Planning Application Ref: 6/2020/0378/COND

Condition 3 of Application 6/2019/0085/MAJ – Replacement Hard Play Sports Pitches: Chancellors School, Pine Grove, Brookmans Park, Hatfield, AL9 7BN (Sport England Ref: PA/20/E/WH/54967)

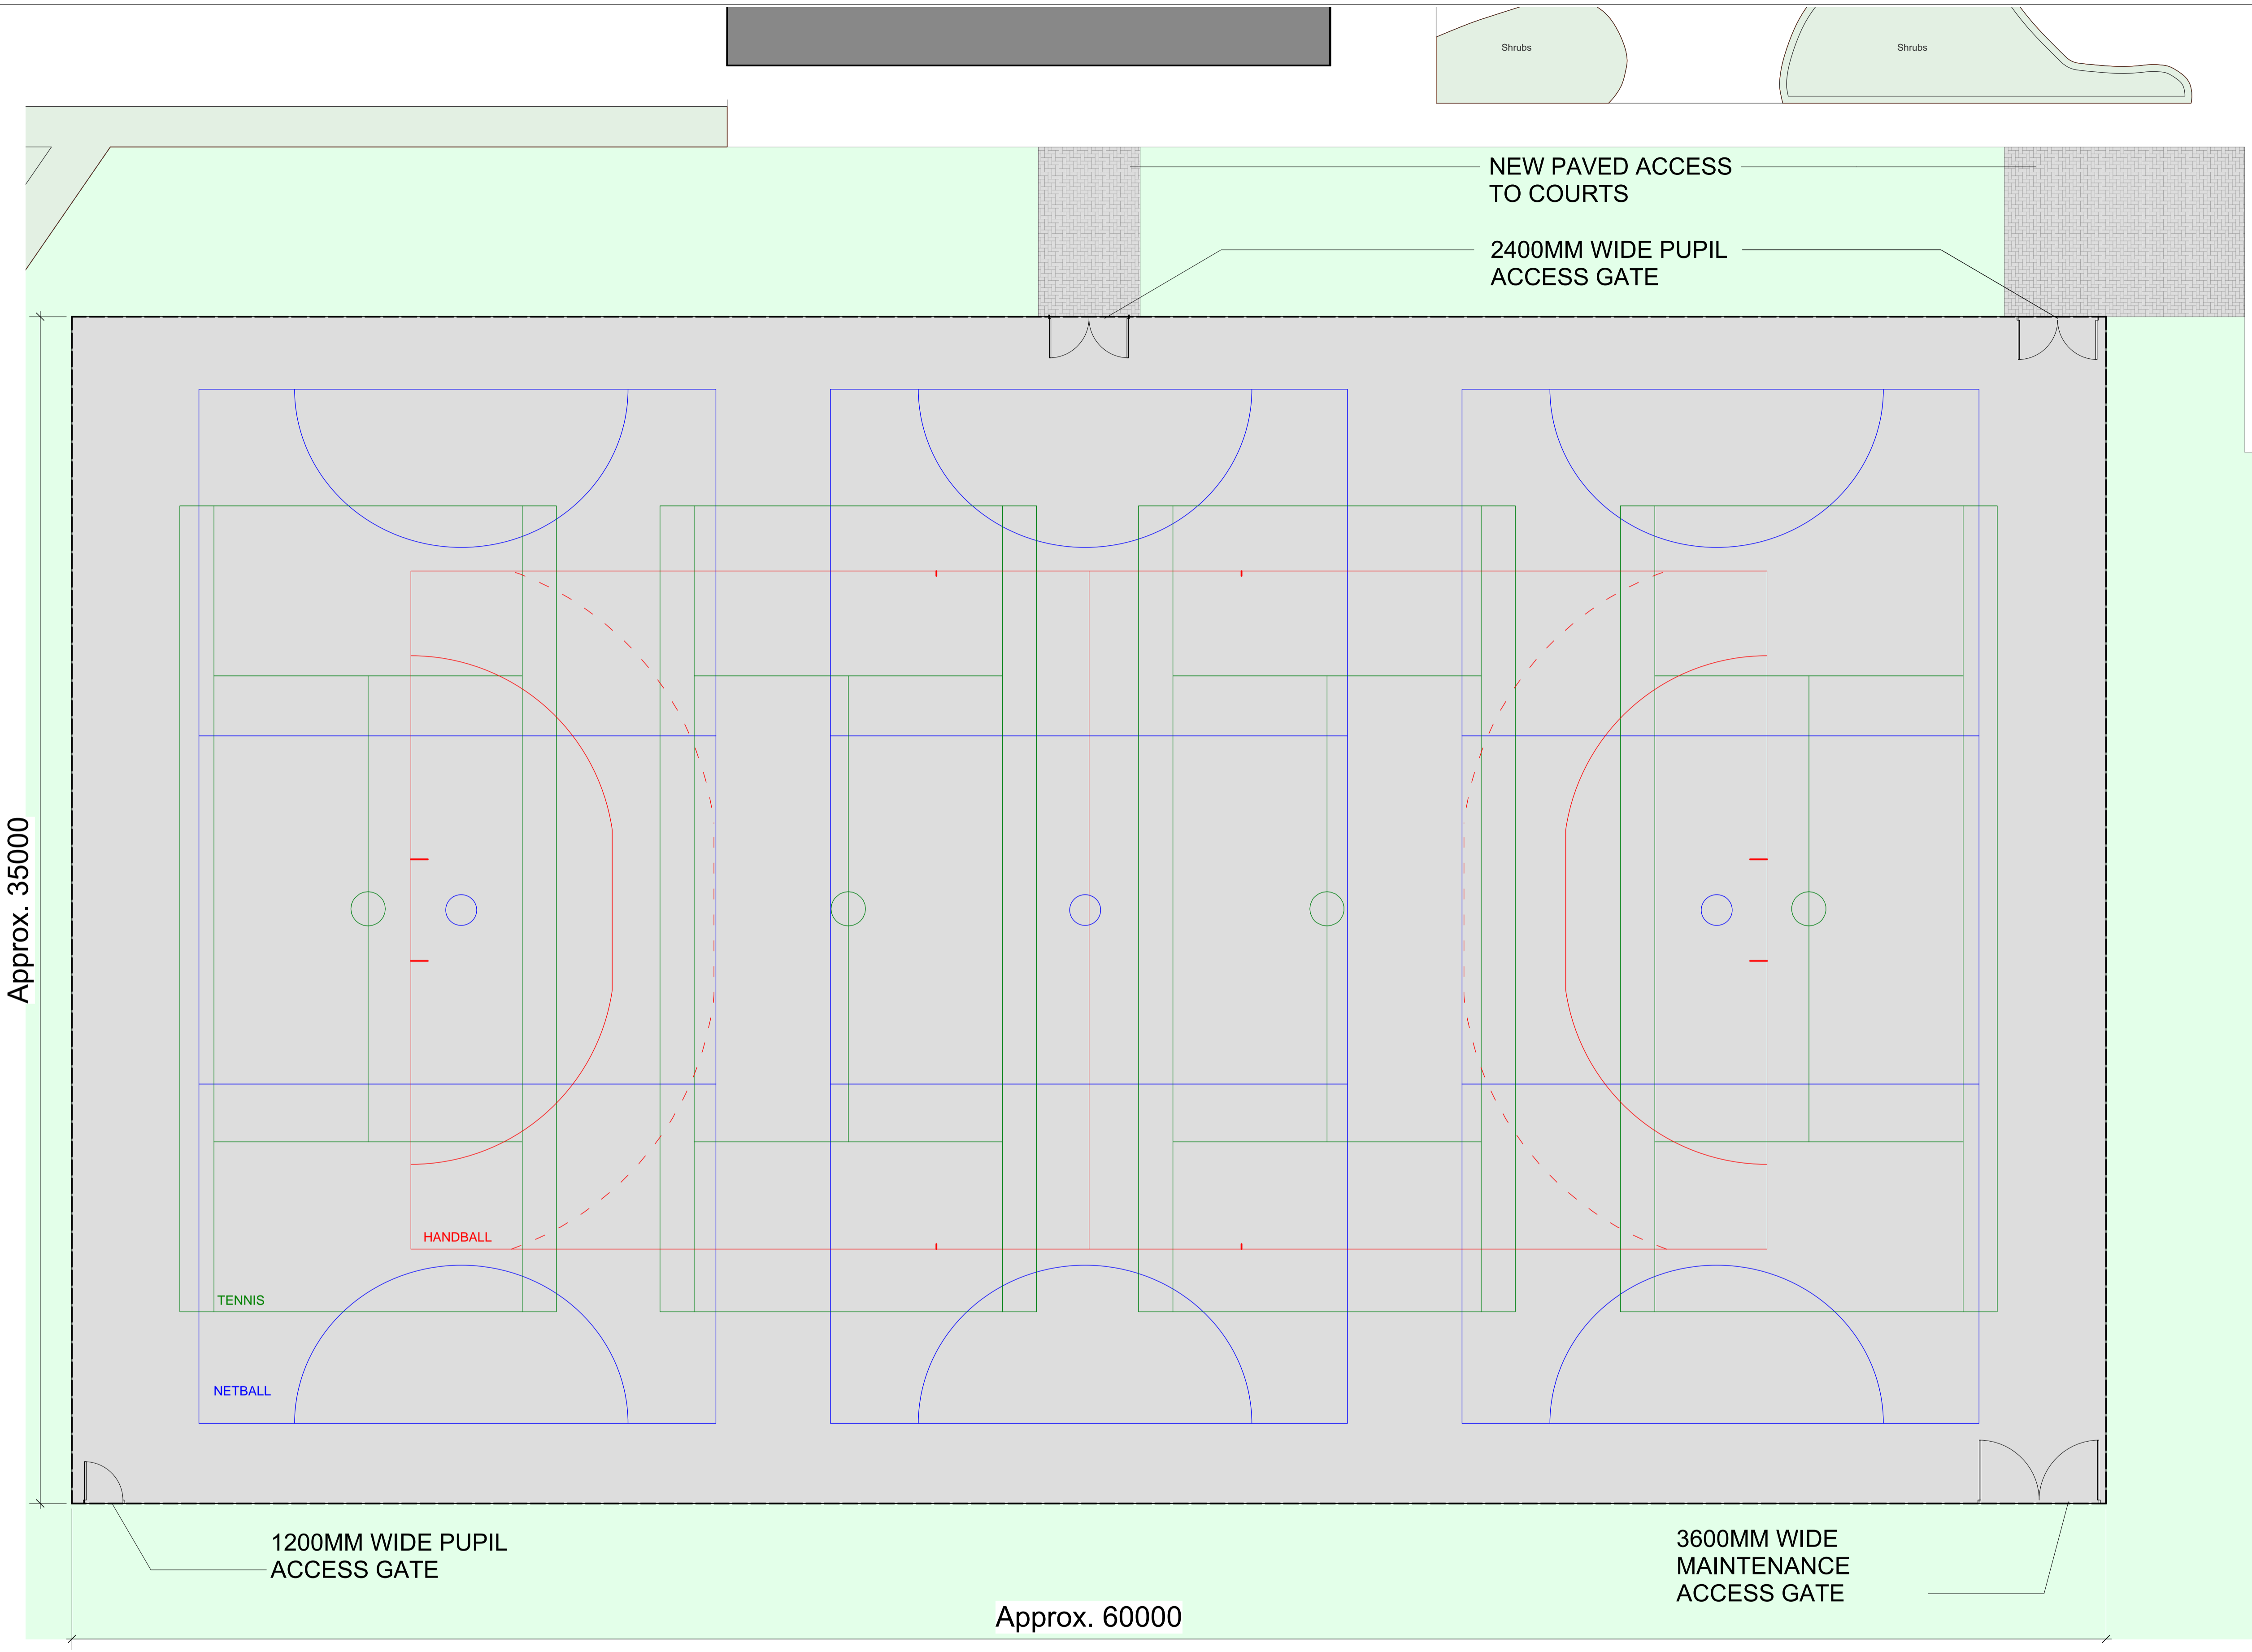
I have considered the drawing (Replacement Hard Standing Sports Pitches Plan) that has been submitted and would advise that there are the following omissions:

- While the plan shows the dimensions of the perimeter of the multi-use games area, it does not show the dimensions of the netball, tennis and handball courts proposed. While this could be assessed from scaling from the drawing, to avoid potential errors, the plan should show the dimensions of the courts and the run-off areas in order to demonstrate that they accord with Sport England's recommended dimensions (see attached document);

- The specification for the proposed fencing including illustrative photographs to show the appearance has not been provided. There is a reference to nylon coated specialist sports wire fencing being provided around the perimeter of the multi-use games area on the plan but no detailed fencing specification has been provided;

- No details of the proposed surfacing of the multi-use games area have been provided other than a reference to new tarmac. Details are requested of whether the surface would be dense or porous macadam as Sport England expects sports multi-use games areas to be porous macadam to accord with our Artificial Surfaces for Outdoor Sports design guidance <https://www.sportengland.org/how-we-can-help/facilities-and-planning/design-and-cost-guidance/outdoor-surfaces> (see page 21).

I can therefore advise that an **objection** is made to the application as the information required to fully meet the requirements of the condition has not been submitted. This would be reviewed if details as set out above were submitted.
